**Consultation Response from KC,
Trees**

2026/90702 Fieldhead, Snelsins Road, Cleckheaton, BD19 3UE

Demolition of existing outbuildings and erection of detached leisure building, car port and annex accommodation associated with Fieldhead, Snelsins Road, Cleckheaton, BD19 3UE

Date Responded: 26/05/2026

PROPOSED SITE PLAN

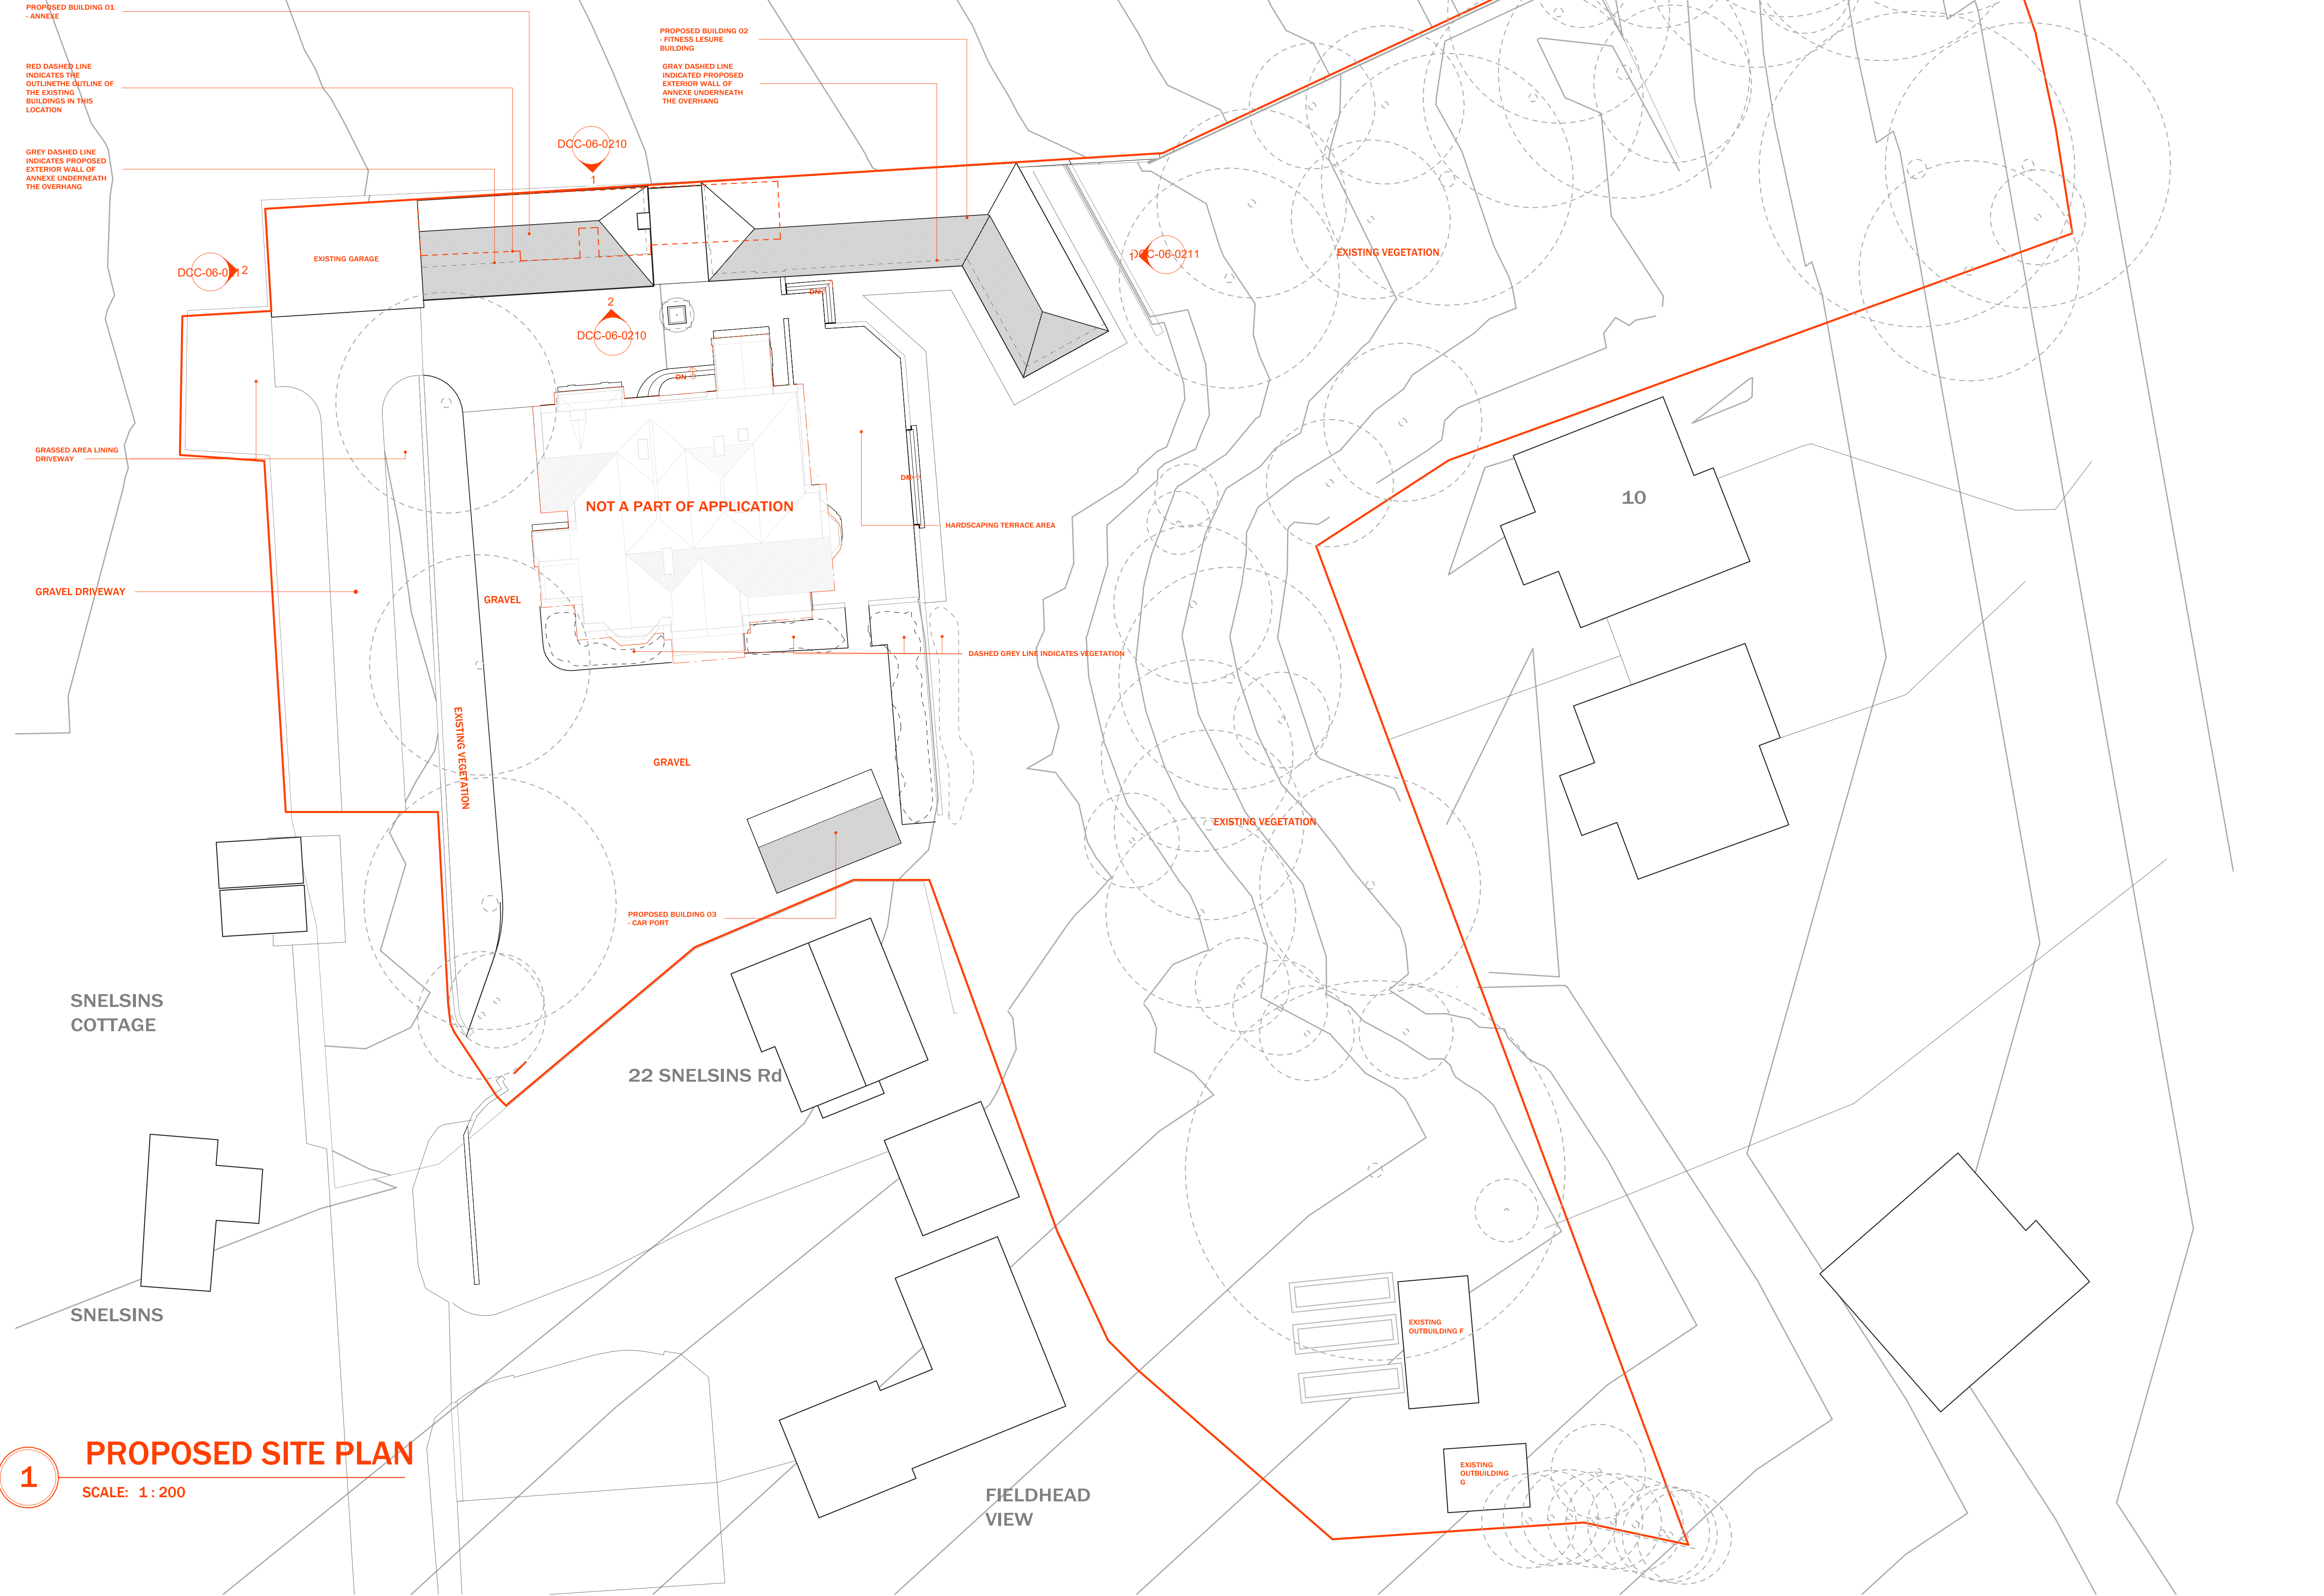
An Arboricultural Impact Assessment ref. 22667d/LW, dated 8th May 2026, has been submitted and reviewed. The proposals are unsuitable from an arboricultural perspective as the pool house is sited significantly within the RPA and canopy of protected Cat B tree **T11**, which would seriously threaten its health and safe long-term retention.

There is an objection from an arboricultural perspective. The proposal conflicts with adopted Kirklees local plan policy 33 and 24 (i).
